re: **Response to City Comments**
 Proposed Residential Development
 475 Terry Fox Drive – Ottawa, Ontario

date: July 14, 2026

file: PG7418-MEMO.01 Revision 4

Drawing Title
GRADING PLAN
(NE CORNER)

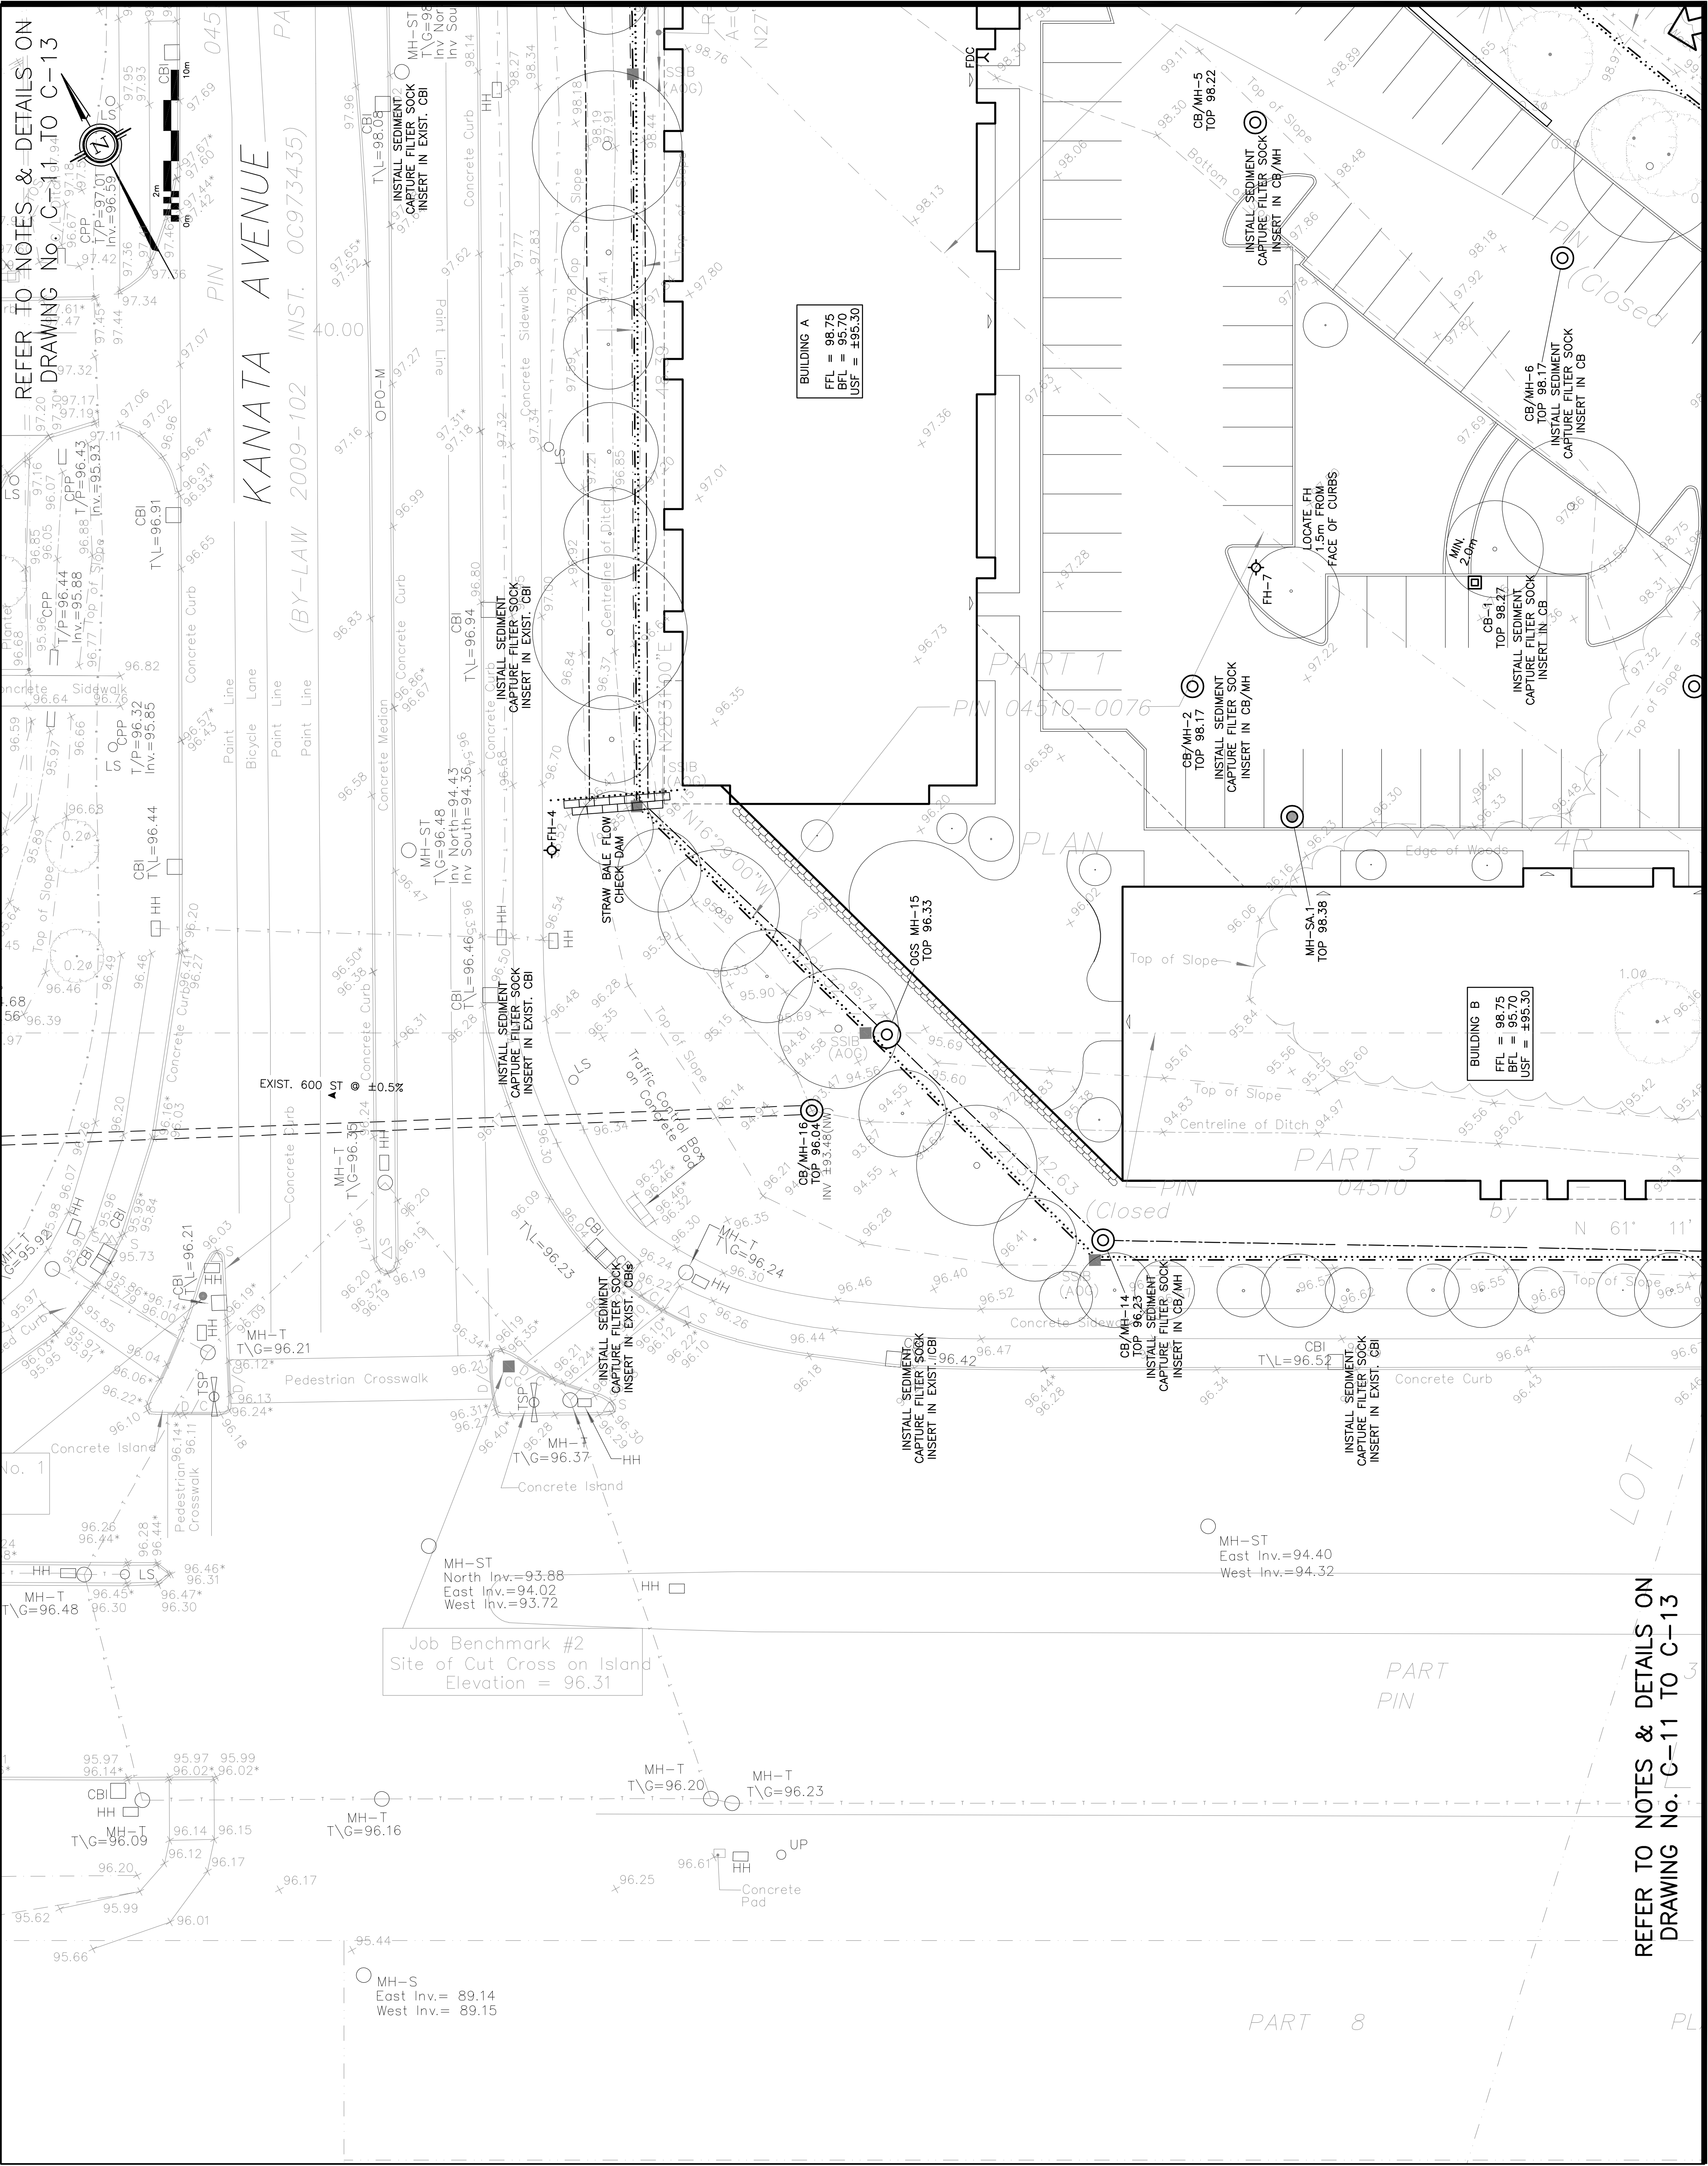
Comment 72: *The following grades from the grading plan are higher than the permissible grade raise, but aren't discussed in your geotechnical memo. Discussion must be provided.*

Response: Reference should be made to Paterson Group Memorandum PG7418-MEMO.02 Revision 4 dated July 14, 2026, summarizing our review of the grading and landscaping design drawings. In summary, the proposed designs are acceptable from a geotechnical perspective. The implementation of lightweight fill has been recommended for a portion of Building B and Building C where grade raise exceedances have been identified and may be mitigated by the recommended measure accordingly. The aforementioned exceedances are considered minor and acceptable from a geotechnical perspective and were considered during the original review dated October 29, 2025.

A A-A: TYPICAL SECTION AT PROPOSED EAST BOUNDARY RETAINING WALL
Scale: NTS

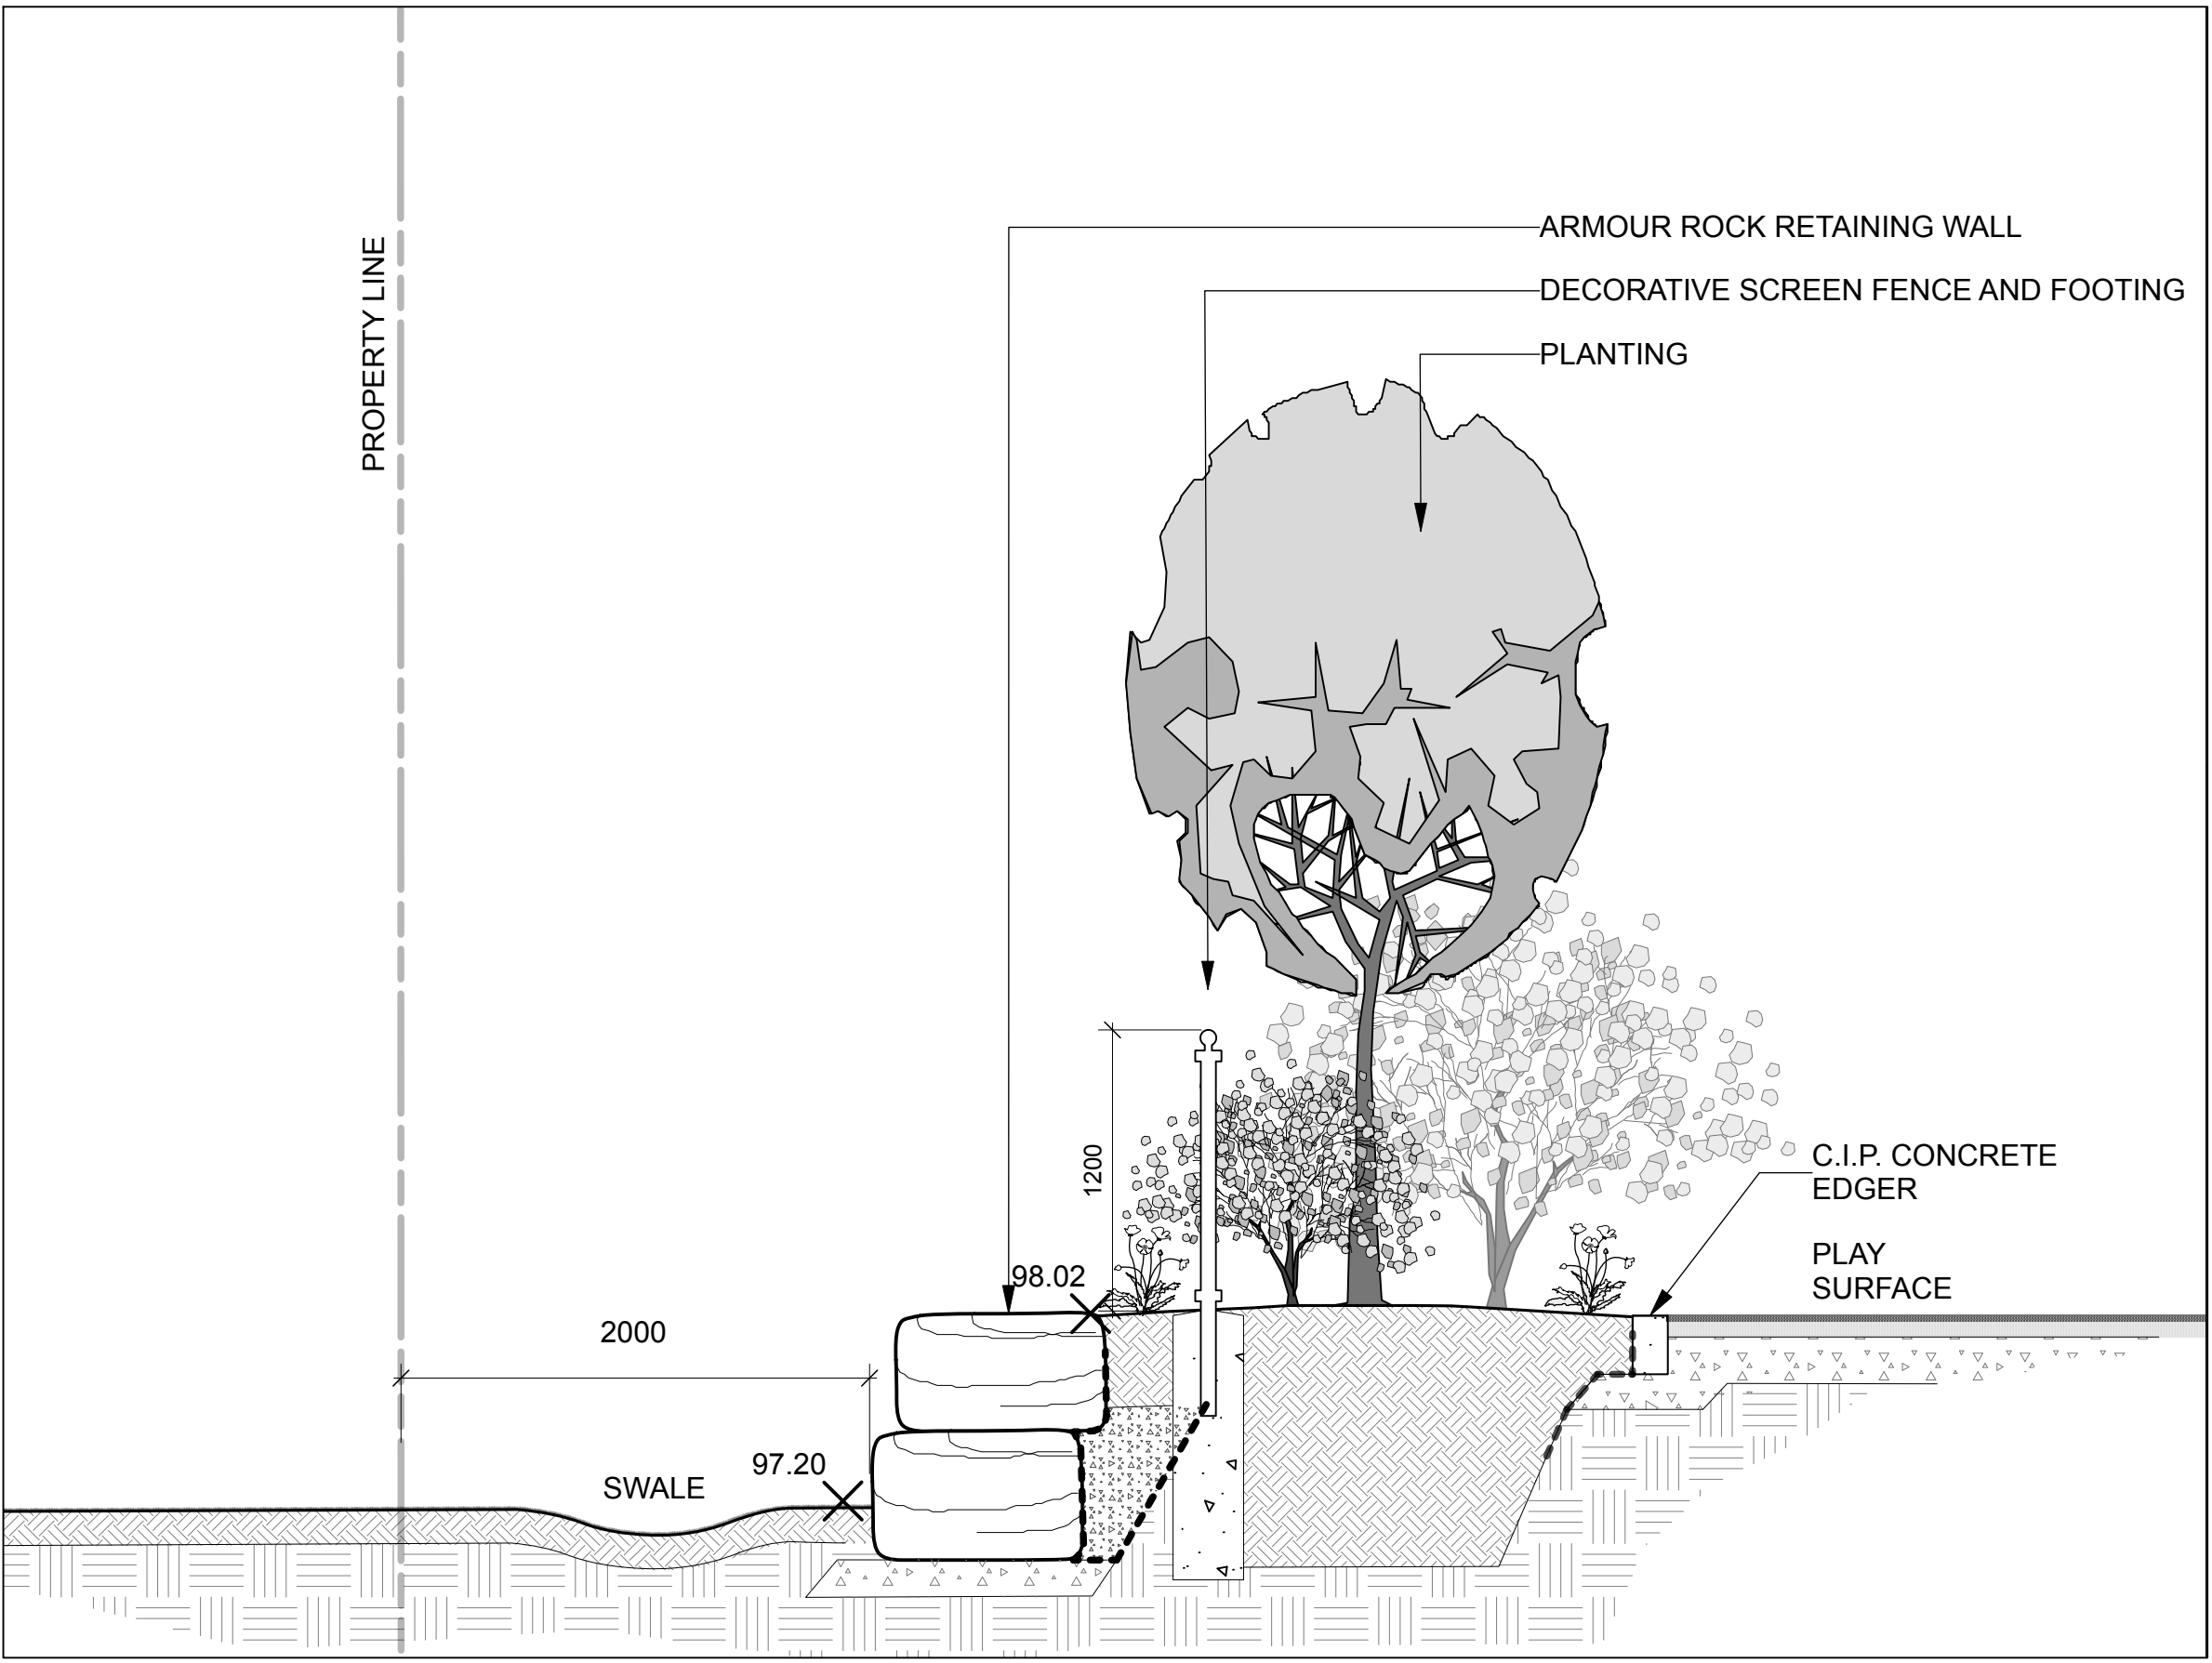
Comment 57: *Are there any minimum tree setbacks from the proposed retaining walls on site? Could the structural integrity of these retaining walls be influenced if trees are being proposed along them, especially the ones planted at the bottom of the wall, where roots could grow underneath the walls footings?*

Comment 73: *Thank you for providing a global stability analysis for the highest section of the retaining wall. Although this is the highest section of the retaining wall, can you confirm that it is also the most critical cross-section that could be analyzed for this site? Perhaps the highest section of the retaining wall may not be the most critical if elsewhere along the wall larger trees are being proposed closer to the top of wall? Please confirm.*

Response: There are no specific tree planting setbacks applicable to proposed retaining walls. However, the retaining wall designer should consider both the additional loads applied from trees in close proximity to retaining walls, as well as the implementation of root barriers to protect the retaining wall systems to resist pressures exerted by root systems. Trees located in front of the wall may be accommodated by thickened and reinforced bedding layers where clay soils may be present at the founding depth of the proposed retaining wall bedding layer.

Response: Reference should be made to our response to Comment #7. In summary, Paterson has confirmed that the section considered is the most critical section and an additional surcharge has been applied to consider the presence of trees equivalent to typical traffic loading.
